RE: SUB19-002/SEP19-005 – Proposed Preliminary Plat
2825 W. Mercer Way, APN 2174502425
Request for Additional Information, Third Review
Blueline Job No. 13-118

This letter is in response to your review of the SUB19-002/SEP19-005 project. The plans have been revised per the comments in your letter dated 1/09/23. Below is a list of each comment with our responses in bold.

2/16/23
 JOB NUMBER:
13-118
 SHEET NAME:
CV-01
 SHT 1 OF 9

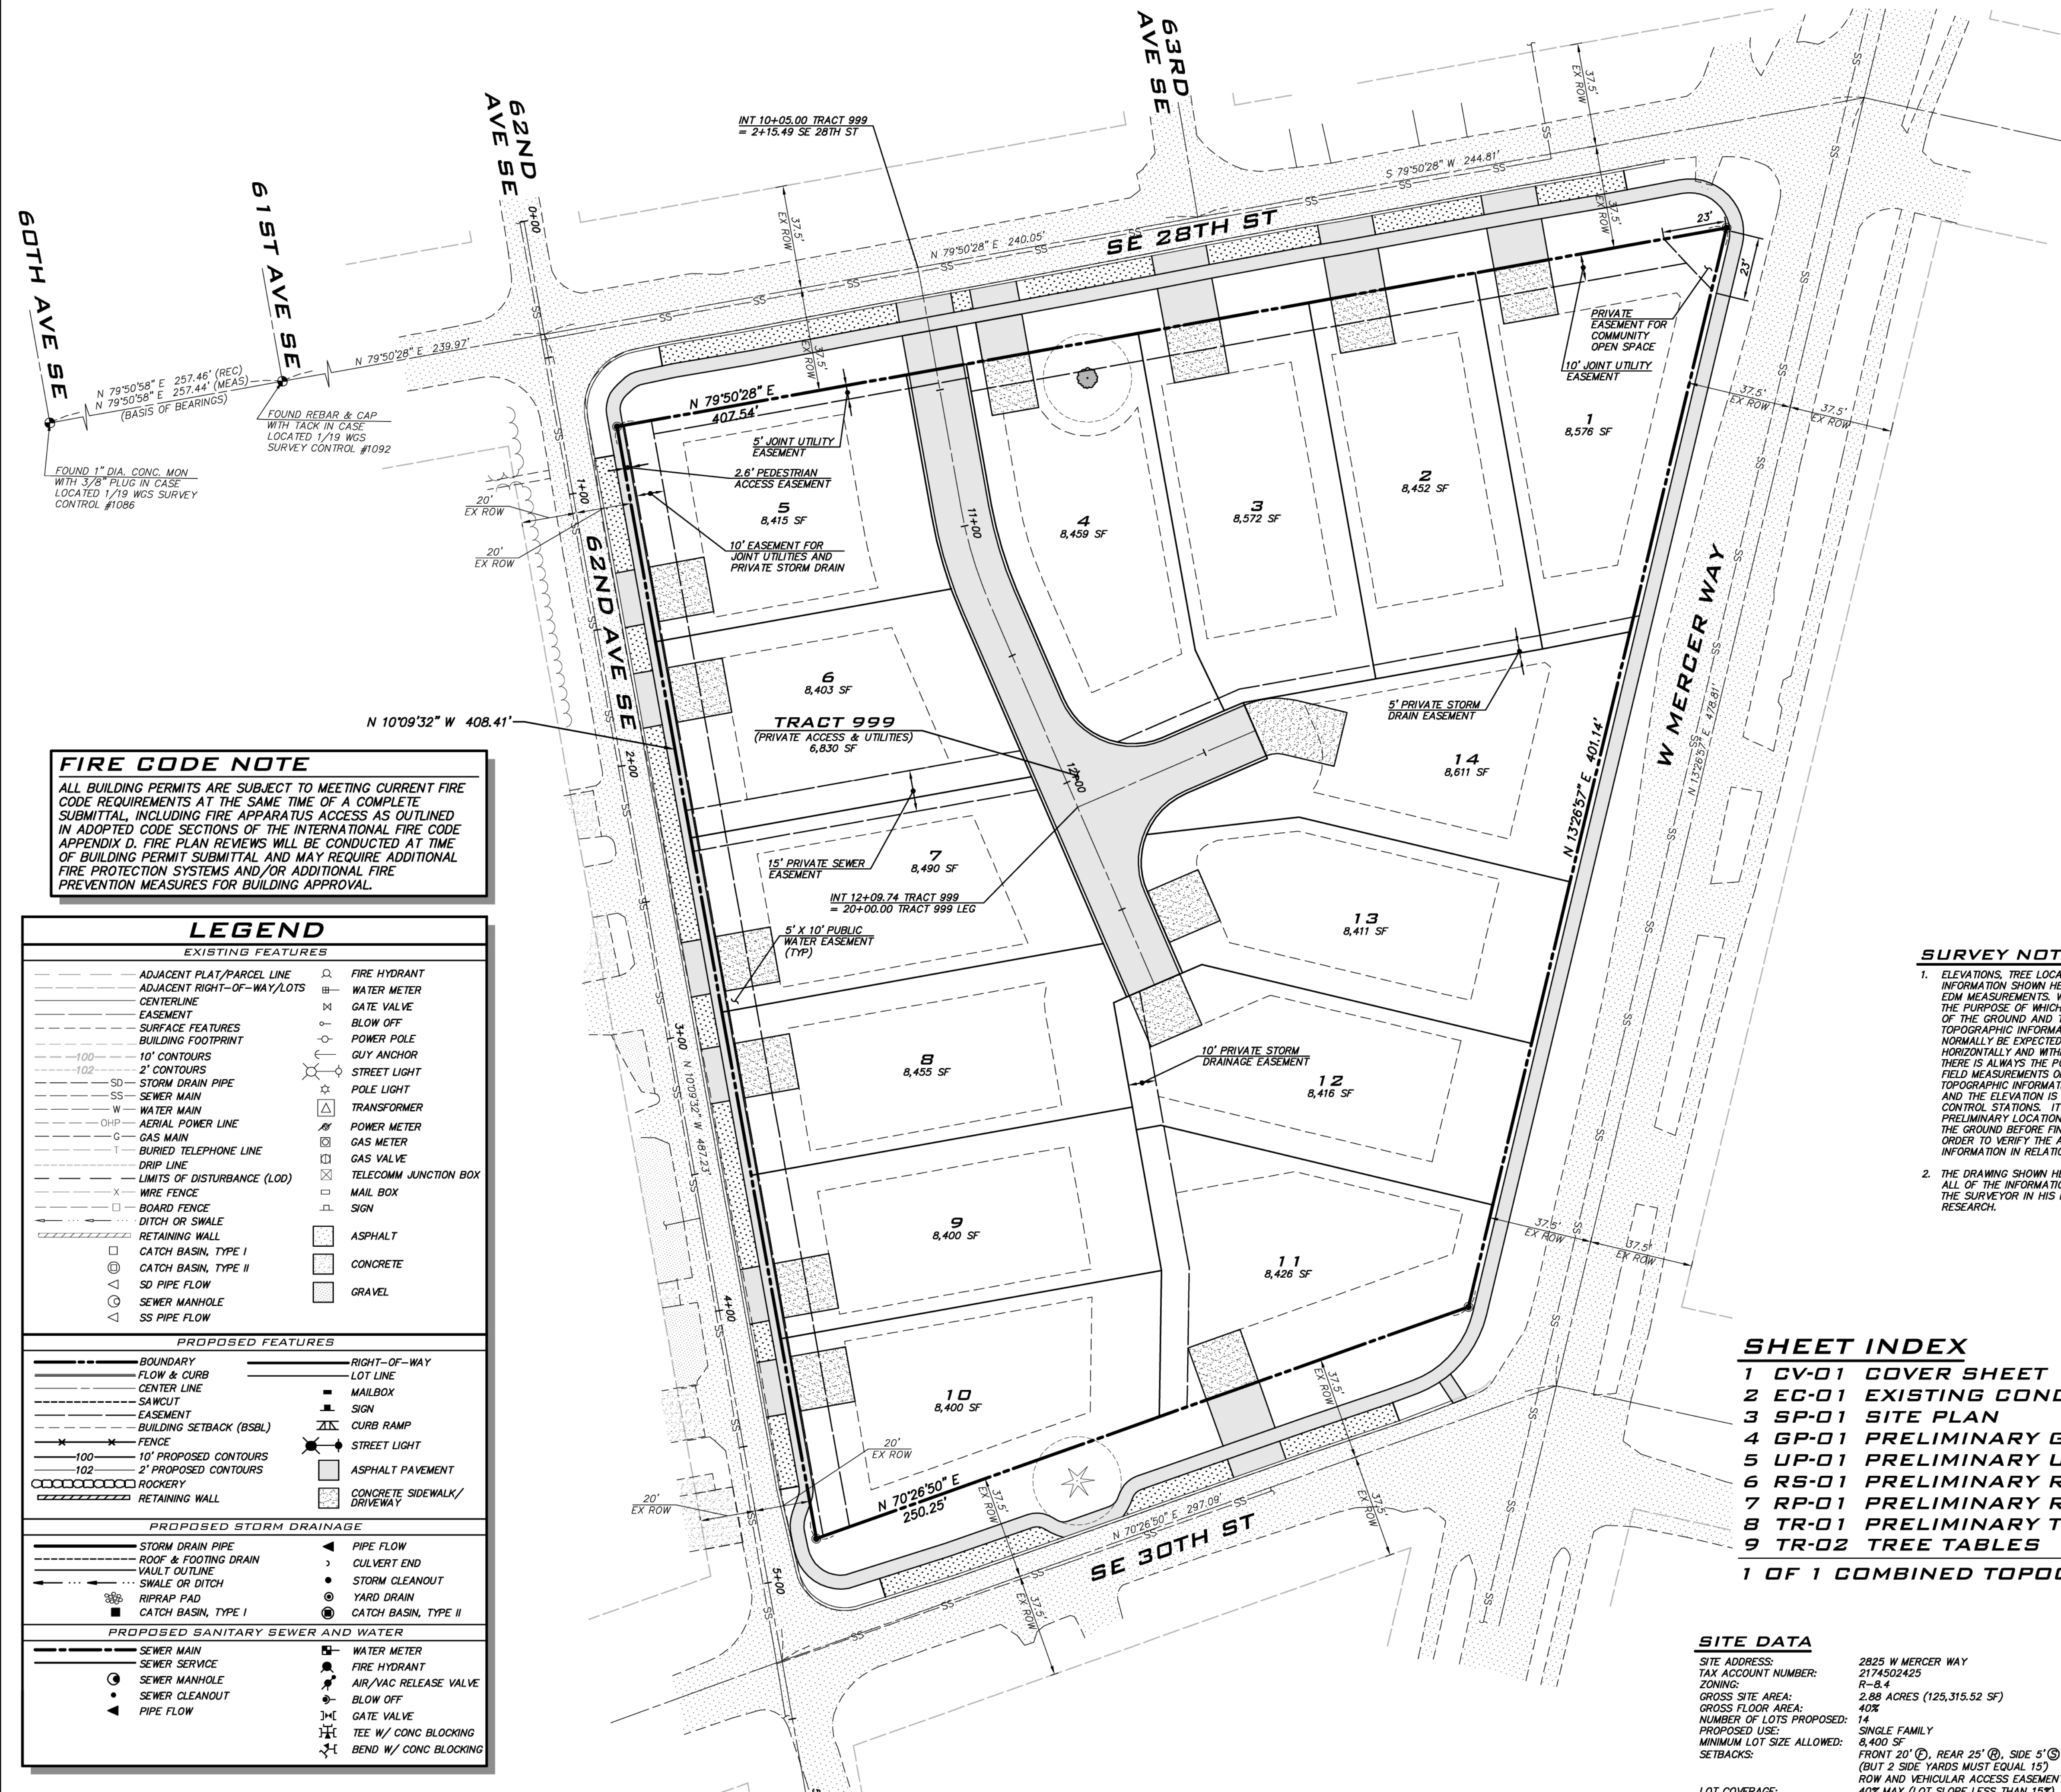
Plat Map Note - Please include this note on your plat map.

"All building permits are subject to meeting current fire code requirements at the time of a complete submittal, including fire apparatus access as outlined in adopted code sections of the International Fire Code Appendix D. Fire plan reviews will be conducted at time of building permit submittal and may require additional fire protection systems and/or additional fire prevention measures for building approval."

This note has been added to sheet CV-01.

2/16/23
 JOB NUMBER:
13-118
 SHEET NAME:
SP-01
 SHT **3** OF **9**

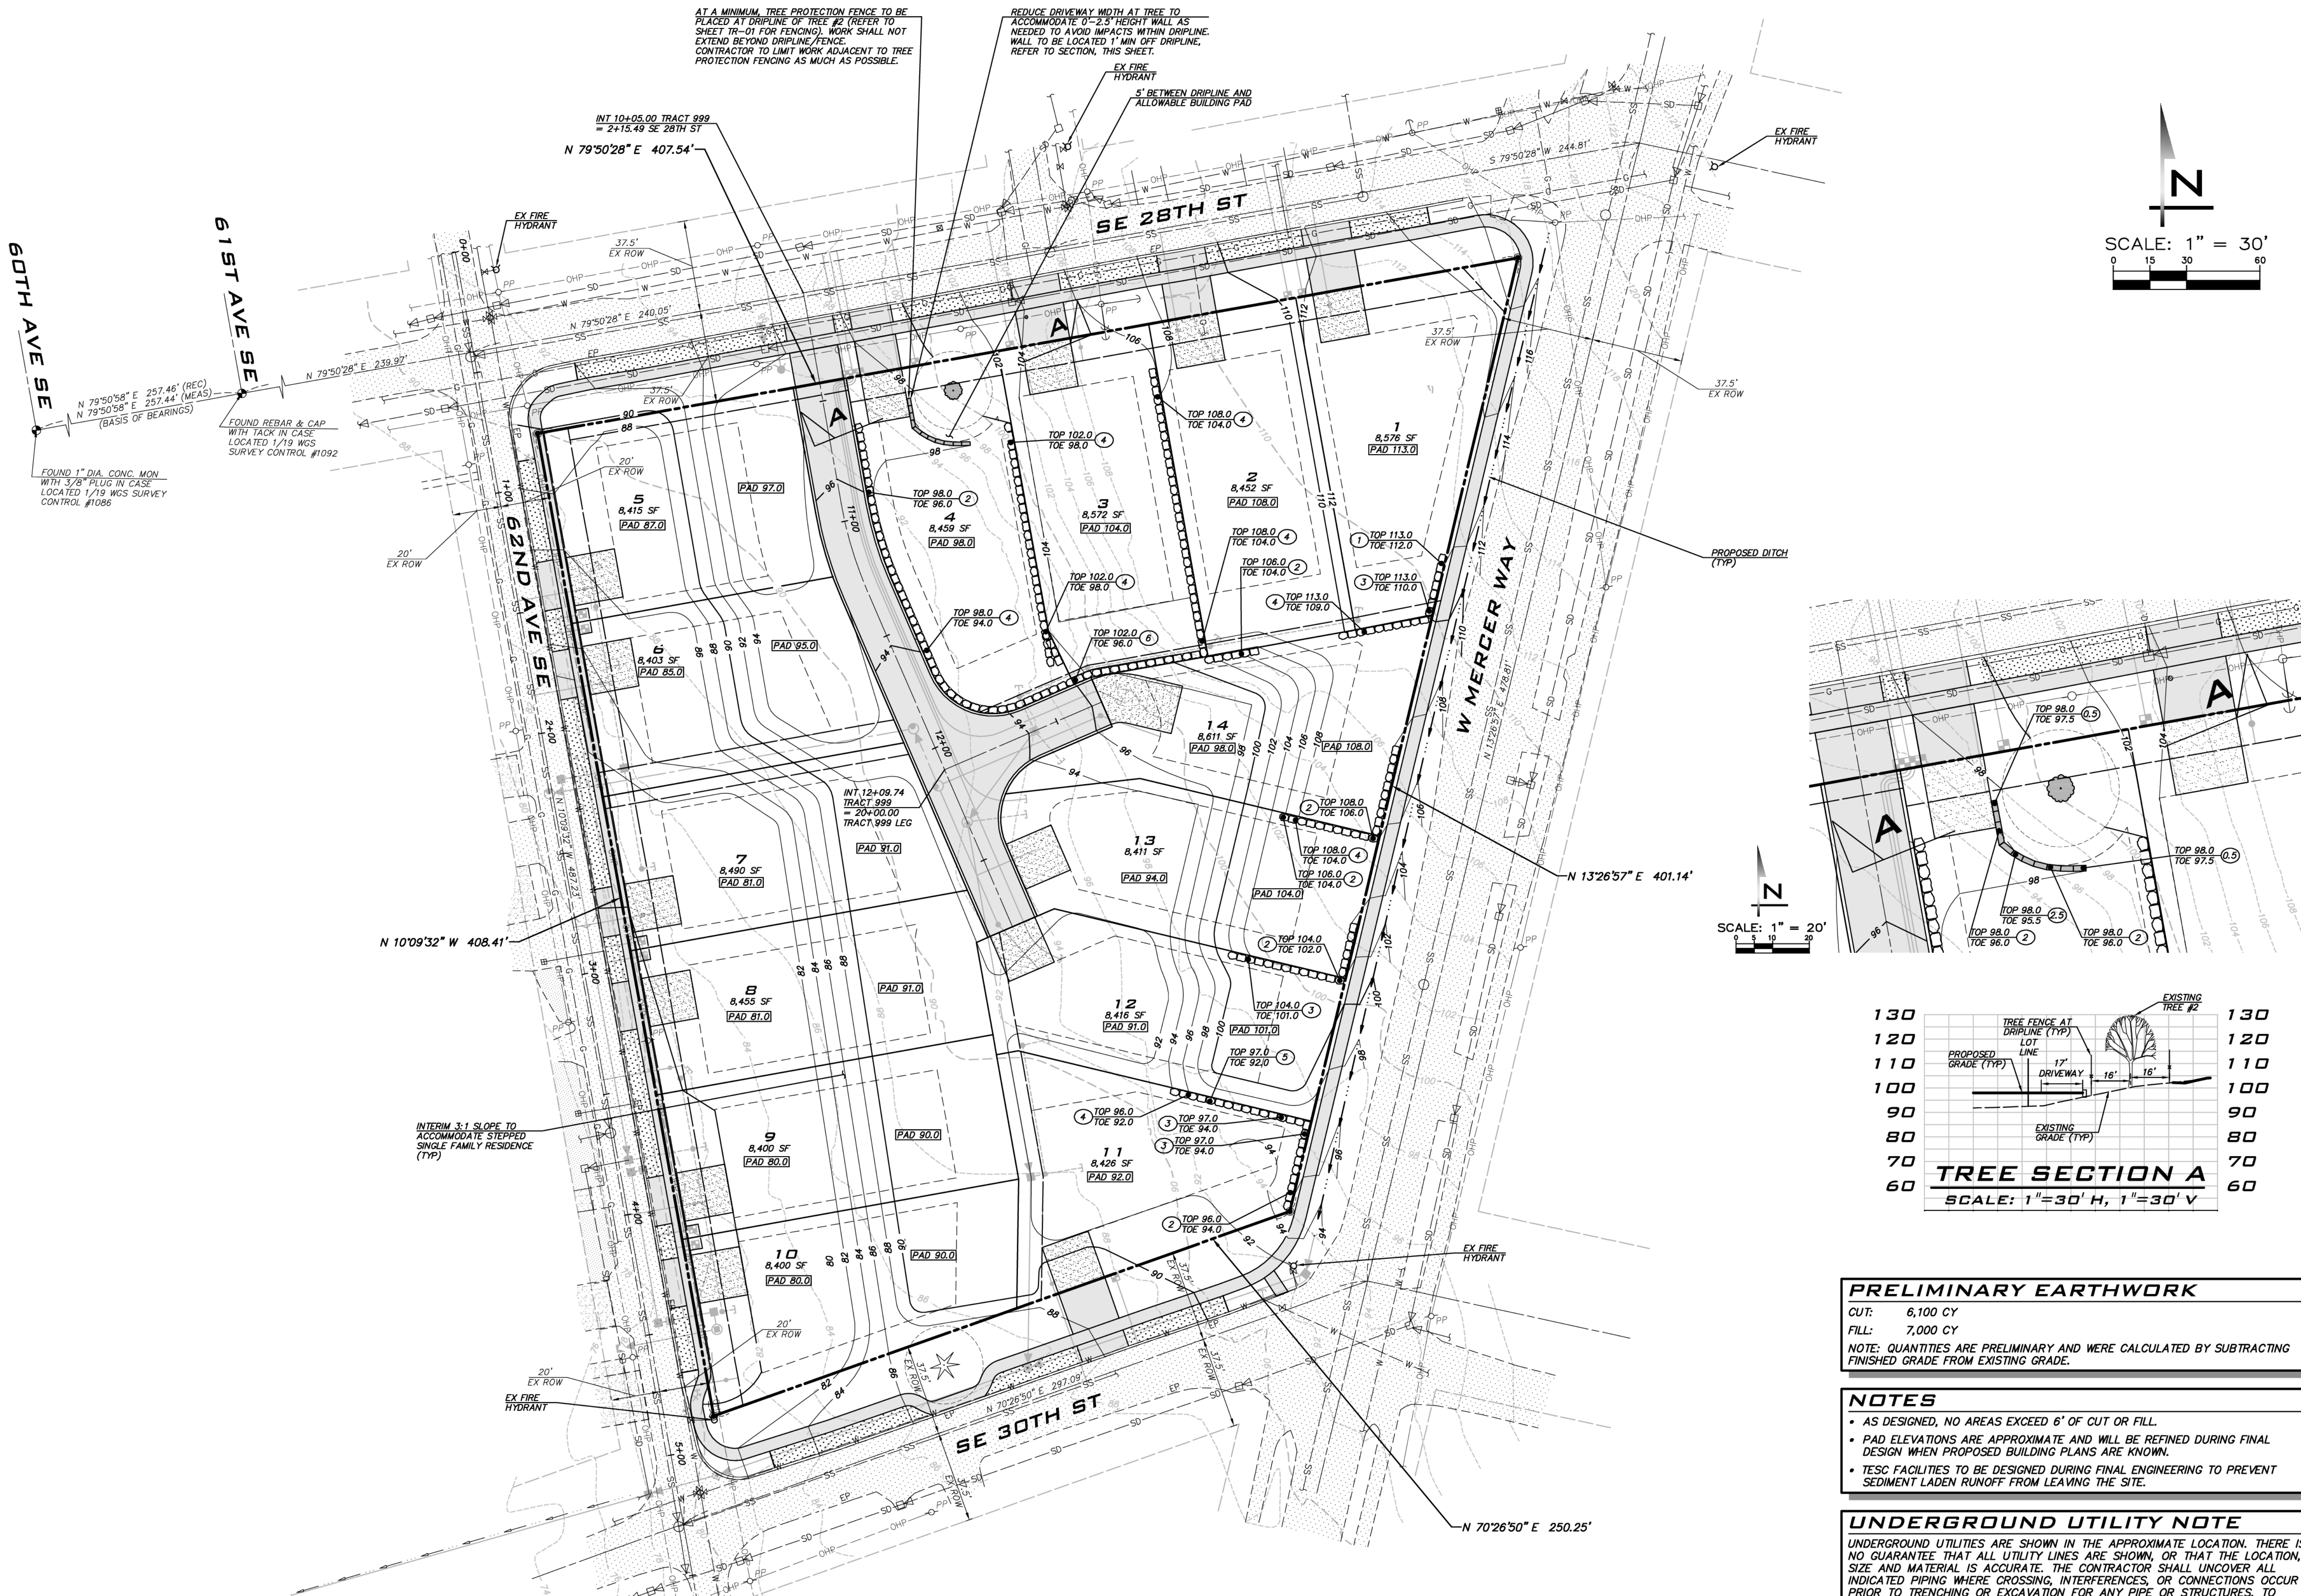
1. The sidewalk at the southwest of the intersection (W. Mercer Way and SE 28th Street) has too many turns and not ADA compliance. The sidewalk is too close to the PSE guy wire. A section of the property shall be dedicated to the City as ROW to accommodate the public sidewalk.

4. The sidewalk along SE 28th Street needs to be located, so the existing catch basins will not be in the middle of the sidewalk or relocate the existing storm drainage system on SE 28th Street.

5. All sidewalks must be ADA compliance.

7. Fire Turn Around- Meets Standards
IFC 503.2.4 The required turning radius of a fire apparatus access road shall be determined by the fire code official. (See Appendix B)
Applicant must identify turn around area on plat map and provide a plan on how this area will be maintained for fire access only and not parked vehicles. Examples would be painted lines (maintenance agreement) and/or signage.

The asphalt path layout at the SW corner of the intersection of W Mercer Way and SE 28th St has been revised. Per email correspondence with the City on 2/10/23, the revised layout at this intersection will be sufficient for the preliminary plat and the detailed design of the paths around the frontage will be reviewed under the Site Development Permit. A callout has been added for the guy wire to be relocated as needed. The revised layout at this intersection provides a minimum of 6" behind the asphalt path for maintenance, and as such, an easement/additional ROW is not needed. This layout will be confirmed following construction to ensure a minimum of 6" is provided behind the asphalt path, otherwise, an easement/additional ROW will be needed.

Per meeting with the City on 1/26/23, the public storm system along SE 28th St has been updated and that will need to be reflected in the drawings for the Site Development Permit. A callout has been added to sheet SP-01 for the asphalt path to jog as needed to avoid existing catch basins.

A note for ADA compliance has been added to sheet SP-01. Additional detail to be provided with the Site Development Permit.

Noted. A callout for the fire turnaround has been added to sheets SP-01 and RS-01.
